Dakota Springs Engineering

Subject: Waterview Final Plat
SF-16-017

This memorandum has been prepared to address the comments you provided concerning the Springs at Waterview Final Plat in your letter dated November 28, 2017. Your comments are provided below with our response comment immediately following in *italics*.

Figure 3: Existing Drainage Plan

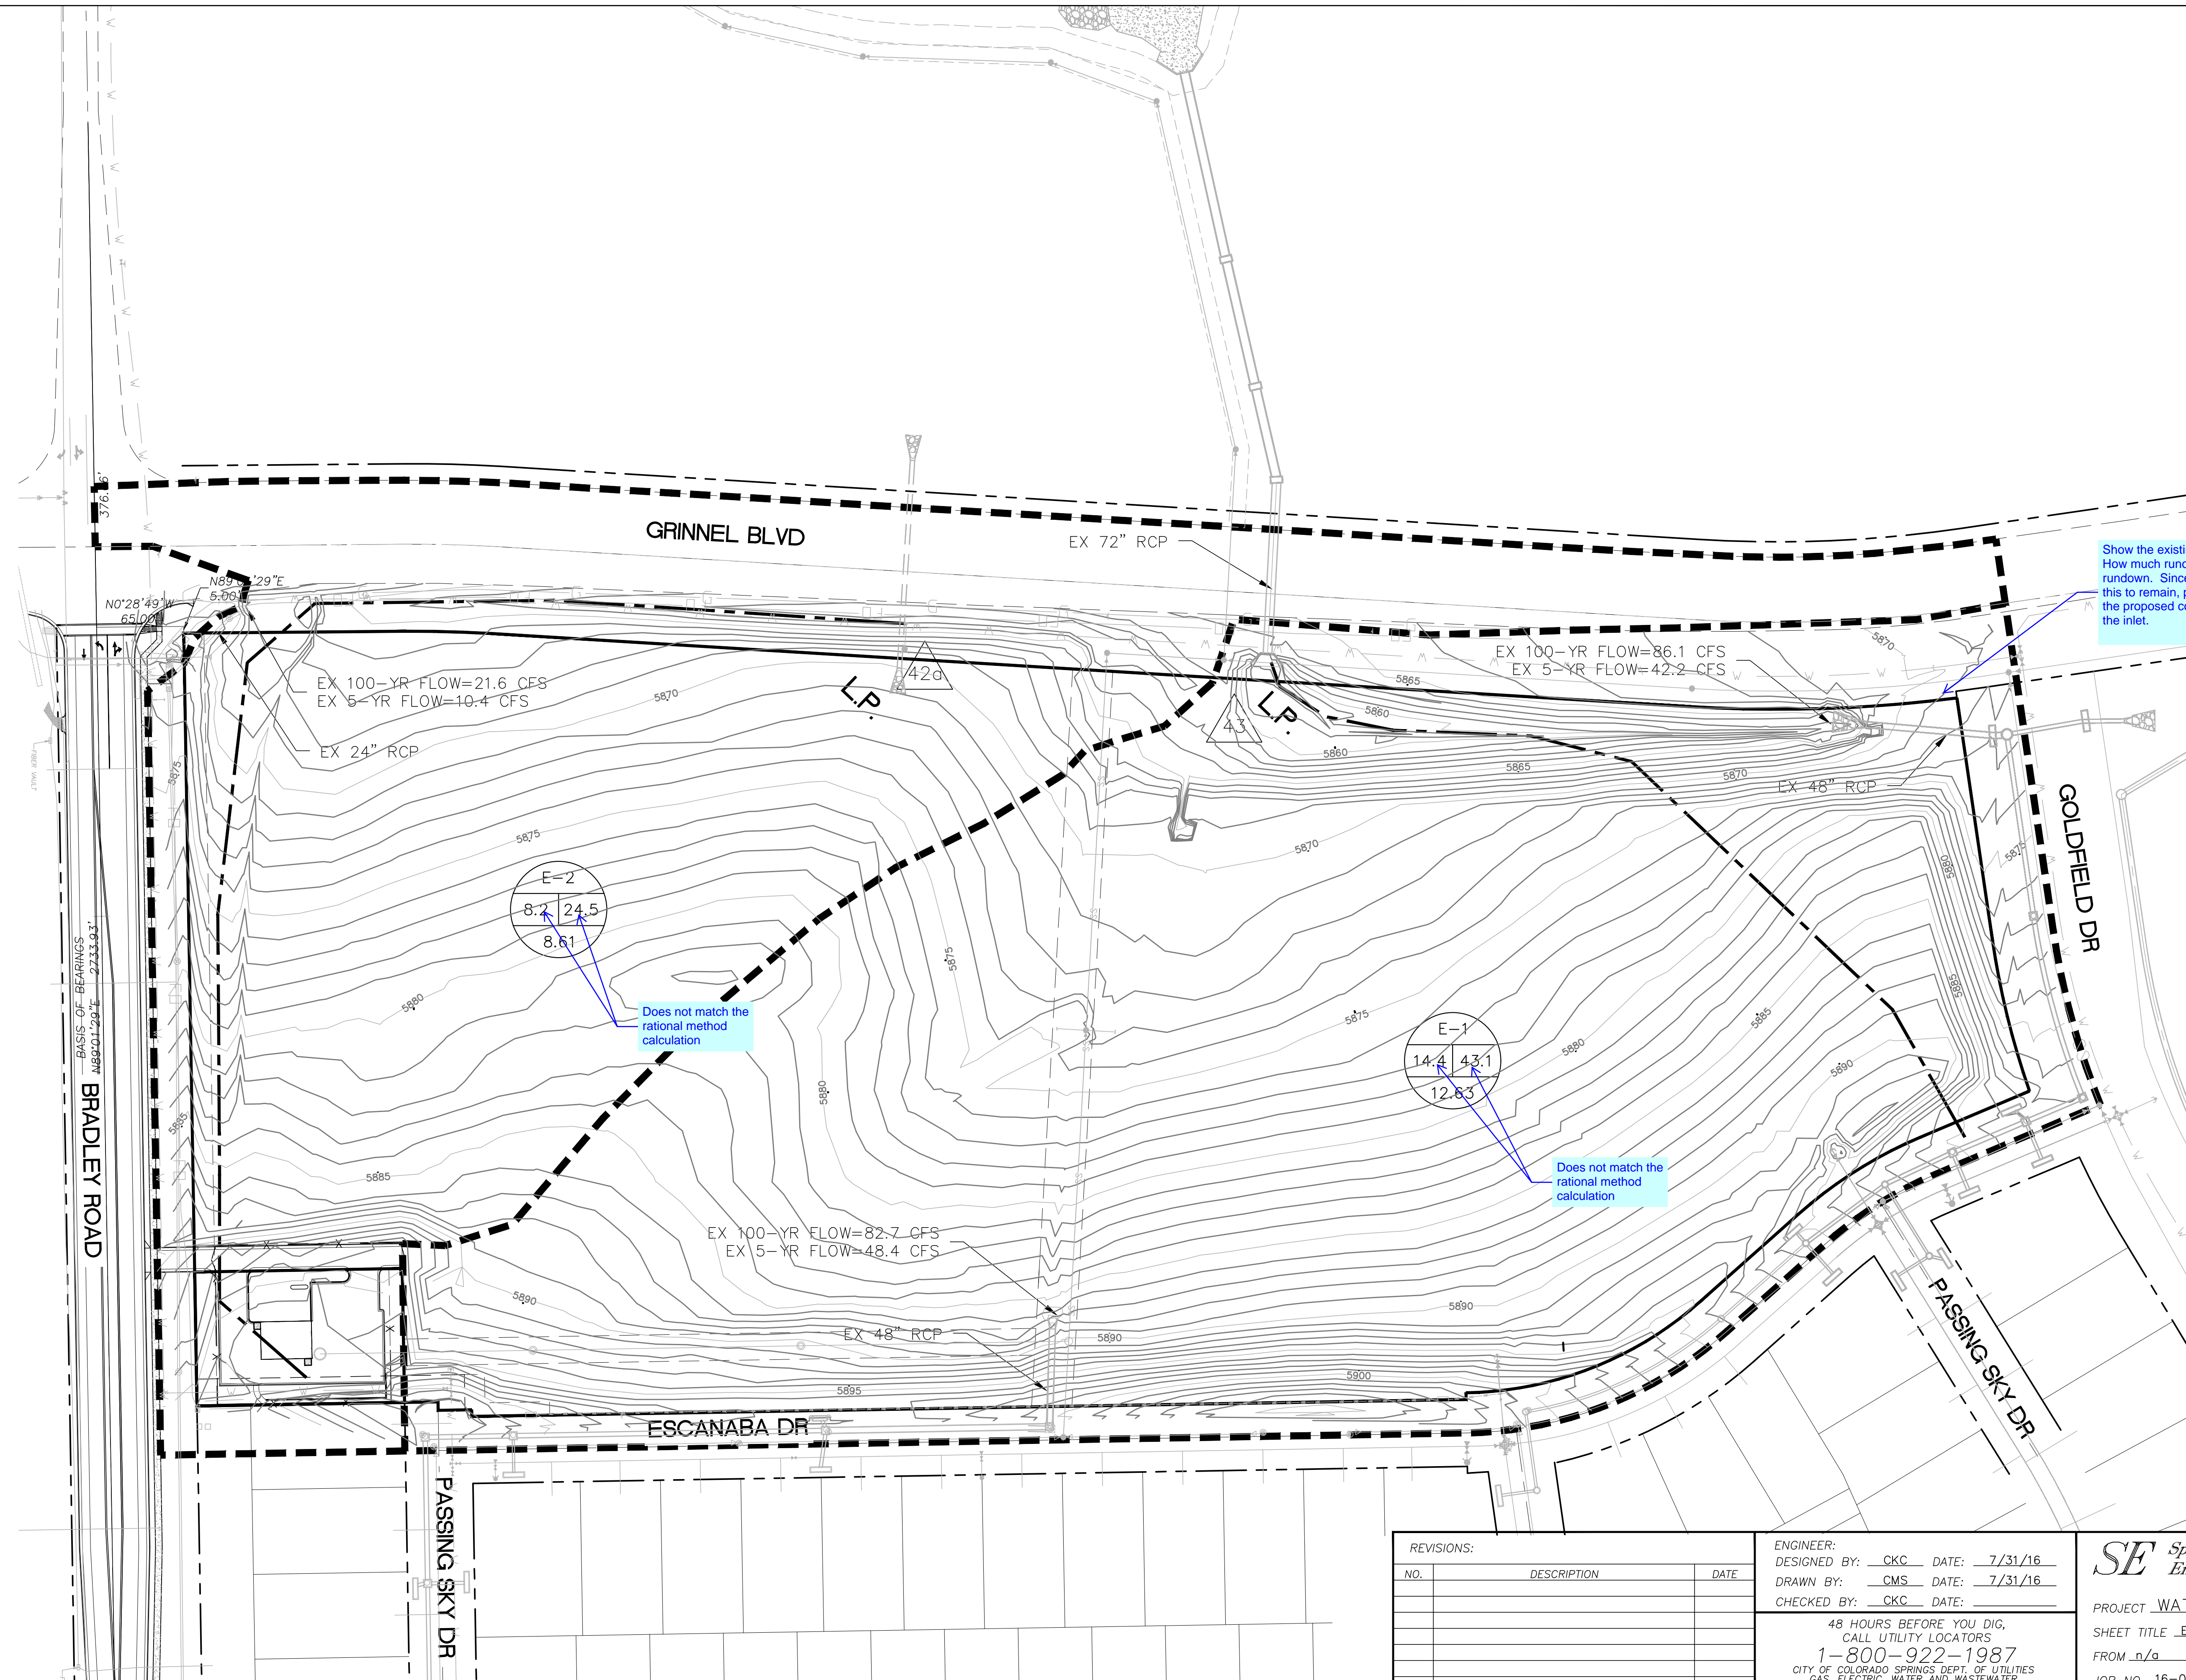
Show the existing road and rundown. How much runoff is being conveyed by the rundown. Since the construction plans shows this to remain, provide the channel analysis for the proposed condition from the rundown to the inlet.

ADDED TO PLANS - ADDRESSED IN REPORT
